OBSERVATION/SUBMISSION TO PLANNING APPLICATION

Case Reference: 323761

Re: Observation/Submission to proposed wind energy development at Cooloo Wind Farm

Applicant: Neoen Renewables Ireland Limited

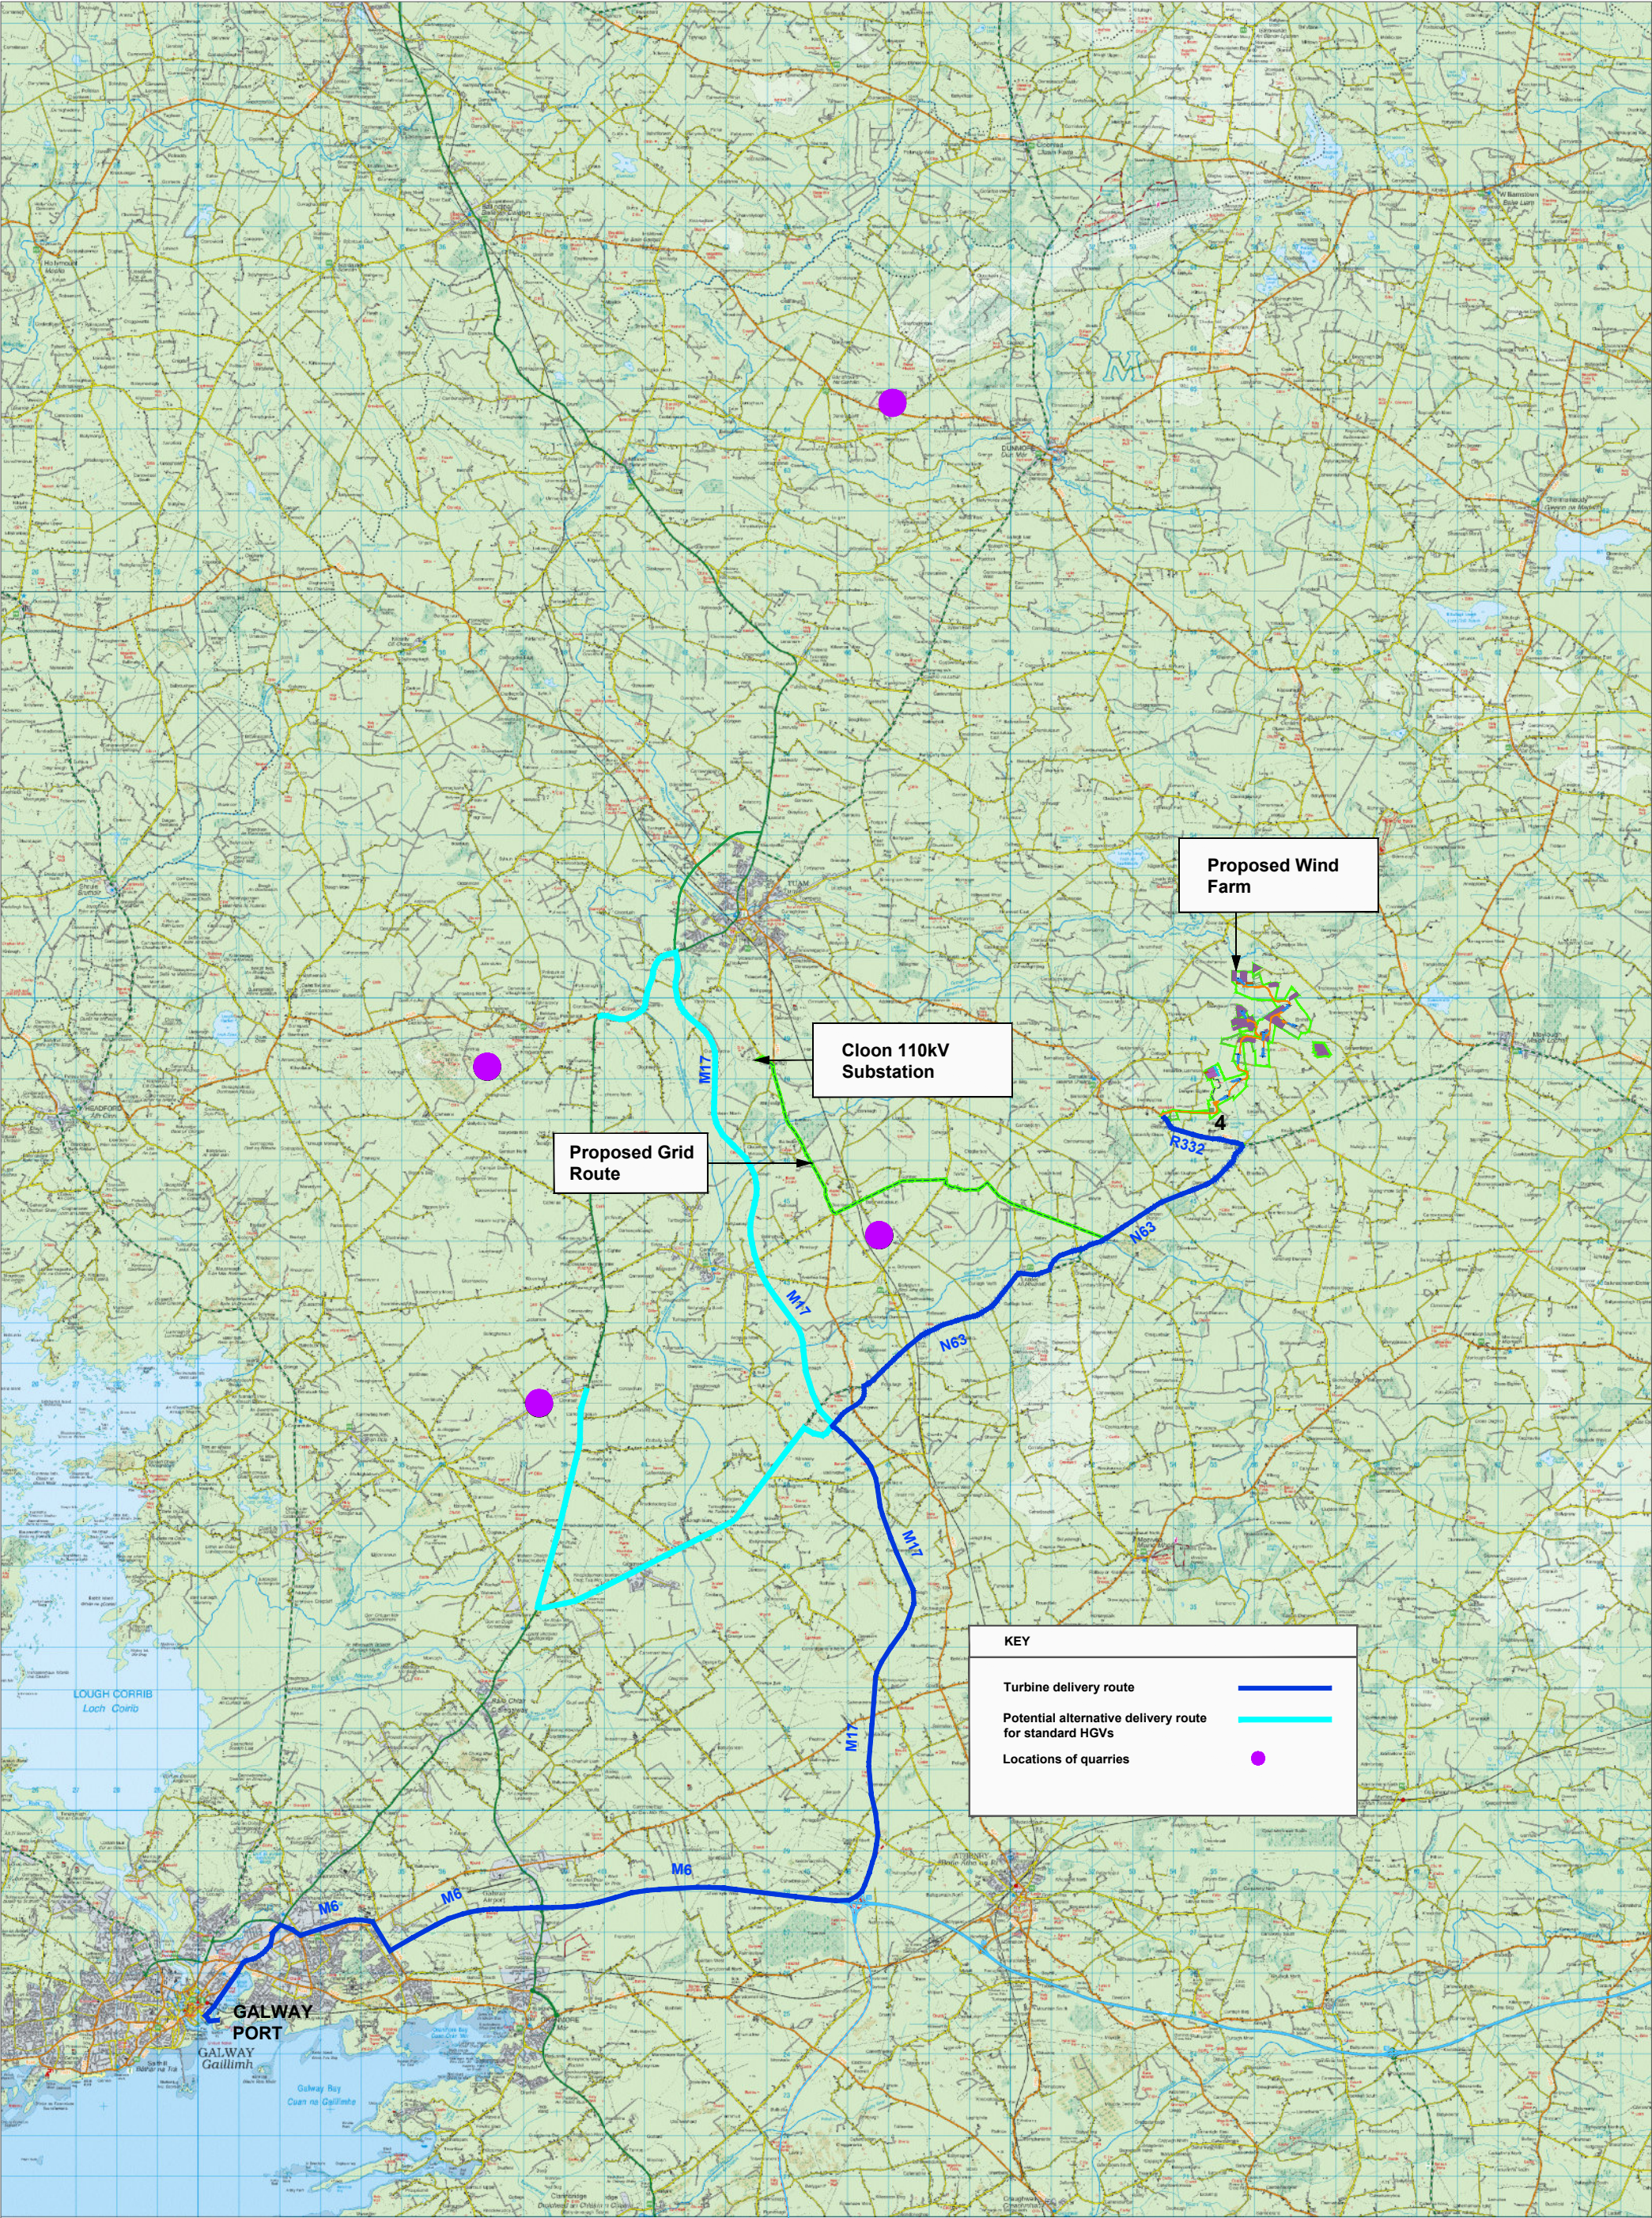
This submission objects to the proposed development due to insufficient traffic management and risk assessment in Appendix 15-2 (Traffic Management Plan). The plan omits essential quantitative data—such as expected abnormal load numbers, peak-phase traffic volumes, and route-specific scheduling—required to evaluate construction impacts. Narrow rural roads near Barnaderg and Cooloo lack the capacity for large turbine transport without pre-works strengthening or verge reinforcement. No detailed programme for road condition monitoring or reinstatement is provided. The TMP also fails to model cumulative or worst-case haulage scenarios, nor does it include enforceable mitigation measures for school transport, farm access or local business continuity. In the absence of these specifics, the project's potential impacts on road safety, infrastructure integrity and rural amenity remain unacceptably high. The application states that locals will kept
